Engineers Comments Regarding Surface Water Drainage

Application Reference:	BE/121/25/DOC	Reviewer Reference:	ADC/EXT5/AF
Planning Officer:	Amber Willard	Date of Review:	20/11/2025
Site Name:	The Cottage Shripney Road Bognor Regis PO22 9PA		
Application Description:	Approval of details reserved by condition imposed under reference BE/176/21/PL relating to condition 26 - as-built drawings of surface water drainage scheme (see BE/120/25/DOC for condition 21 - cycle parking spaces).		
Assessment Number:	1

- As-built drainage layout B.03.1

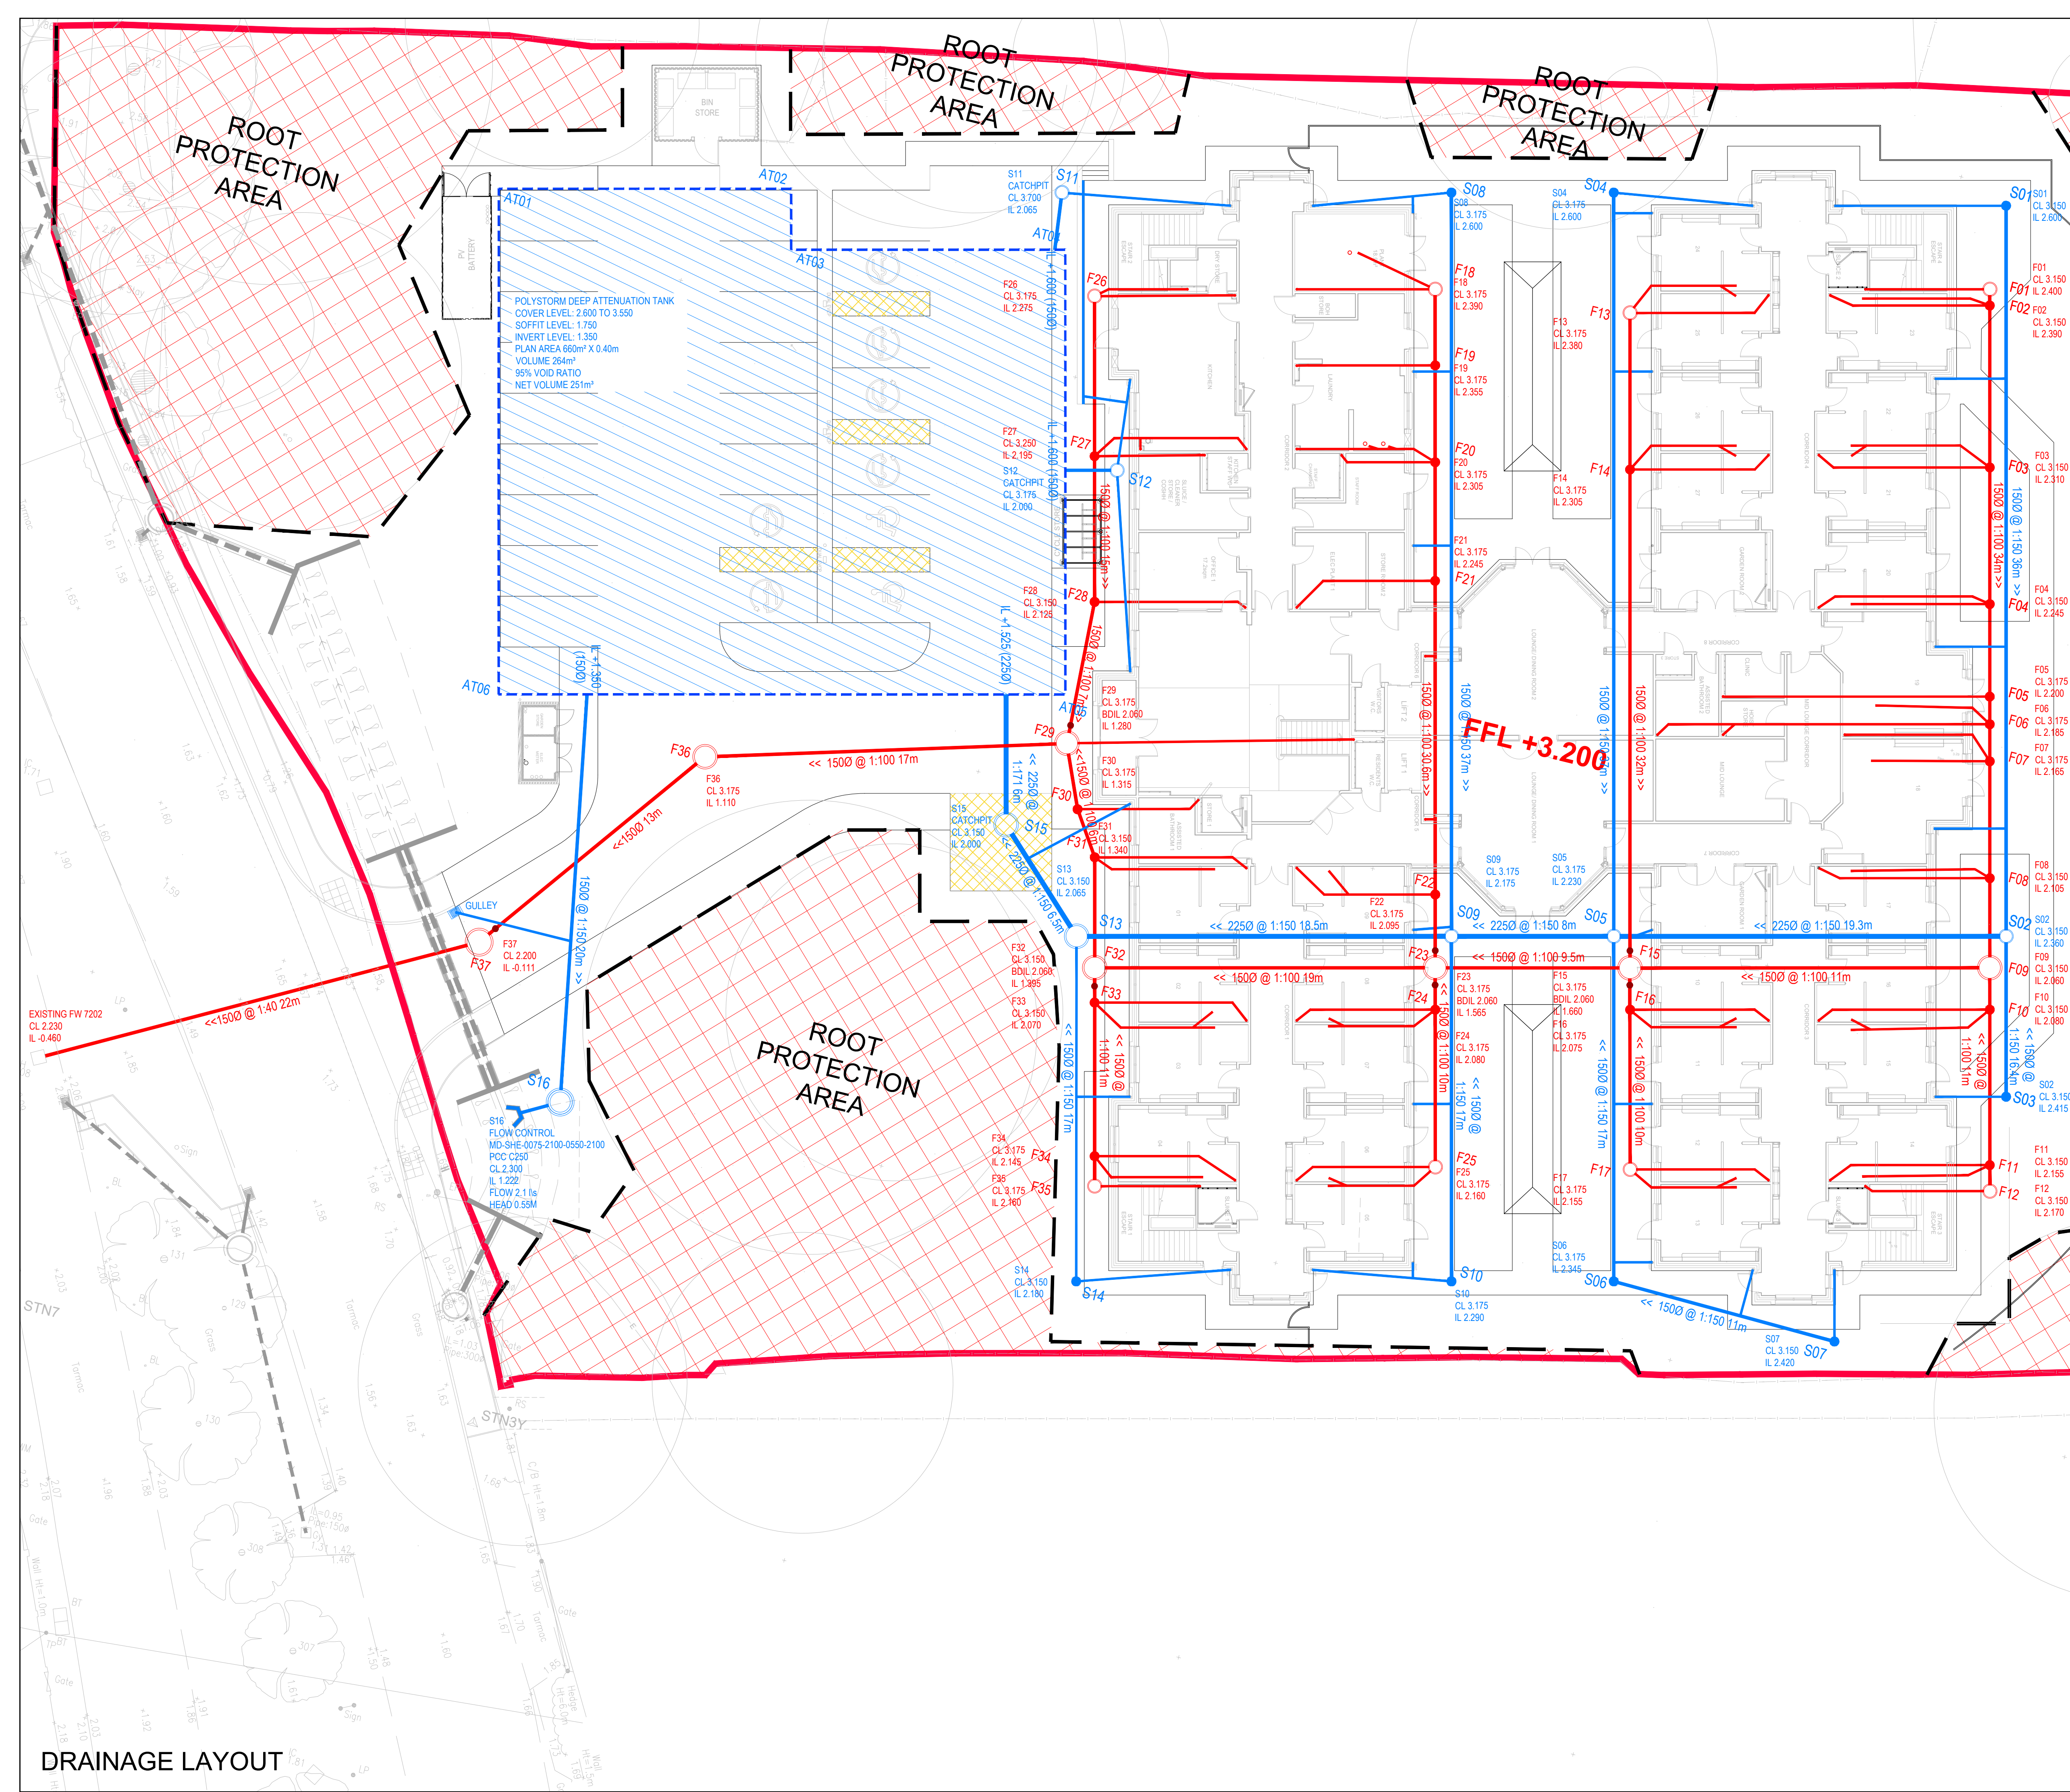
ADC Drainage Comments	Designer Response			
Date:	20/11/2025				
Condition Number: 26 as-built drawings of surface water drainage scheme					
Comment Number					
1.	A report should be provided by an independent engineer with supporting evidence which confirms that the scheme was built in accordance with the approved drawings and is fit for purpose. See ADC Verification Checklist on ADC webpages, link: www.arun.gov.uk/surfacewater				
2.	The area, depth and volume together with the product type of the attenuation tank should be evidenced.				
3.	The flow control device product and completed installation should be evidenced.				
4.	The completed culverted section of the watercourse and drainage outlet should be evidenced.
